COUNTY COUNCIL'S RESPONSE TO CONSULTATION ON THE FOLLOWING DEVELOPMENT PROPOSAL

Application No: 21/00517/F

Proposal: Creation of a motocross track and soft landscaping scheme and the change of use of agricultural land to hold moto-cross events including set-up, take down and private practice sessions, with associated camping site, for up to 65 days per year and agricultural grazing (retrospective)

Location: Land Used for Motorcross, Stratford Road A422, Wroxton

Figure 6 Landscaping plan, existing and proposed features

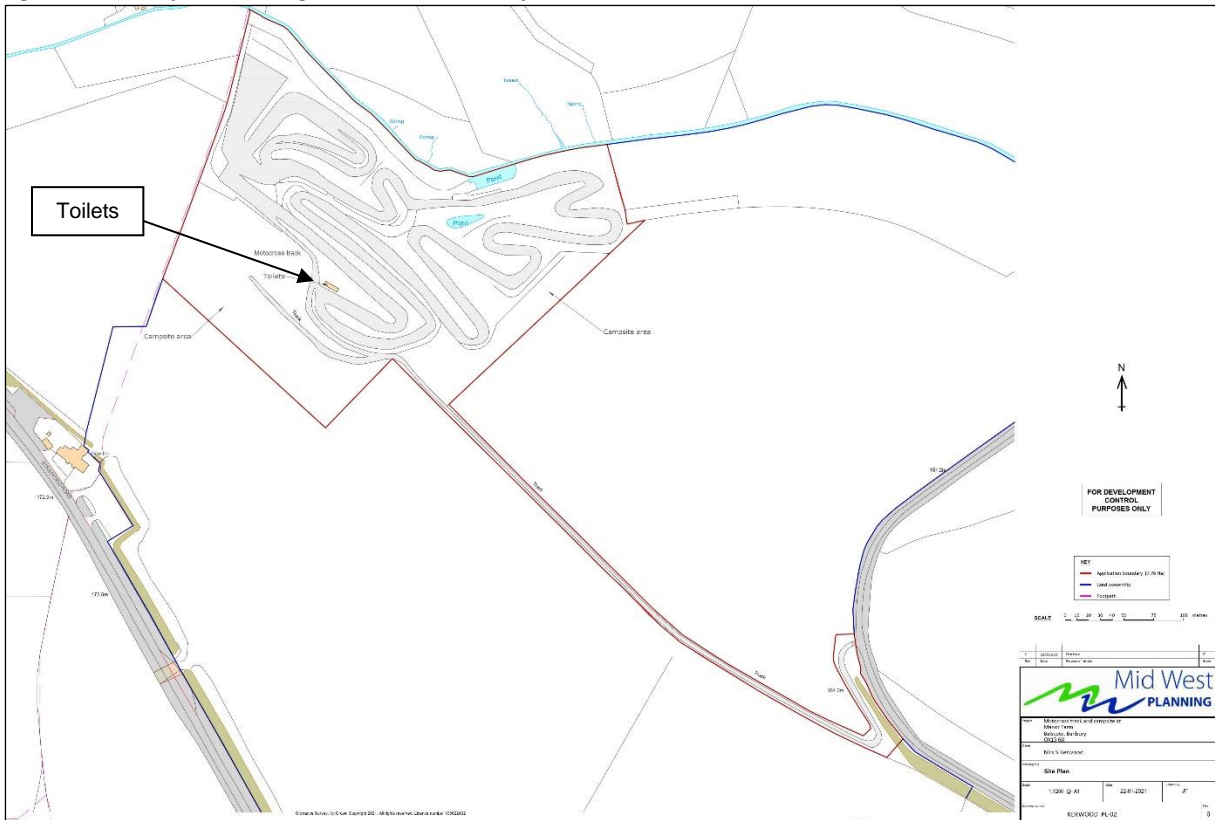
Public footpath 339/18/10 follows the alignment of the western boundary, outside of the site. It is noted on the Landscaping Plan that a 'new mixed native species hedge' is proposed to be planted along this boundary. However, it is considered that a hedge on its own will be insufficient to prevent persons from crossing the boundary, in either direction, between the footpath and the racetrack site. A substantial fence needs to be installed behind the hedge – this does not have to be 'solid' but must be robust, i.e. more than livestock fencing. The fence should extend along the western and south-western boundaries of the site. It is recommended that either the Landscaping Plan is updated to show such a fence, or a suitable condition is applied.

Condition relating to the provision of a fence along the western and south-western boundaries.
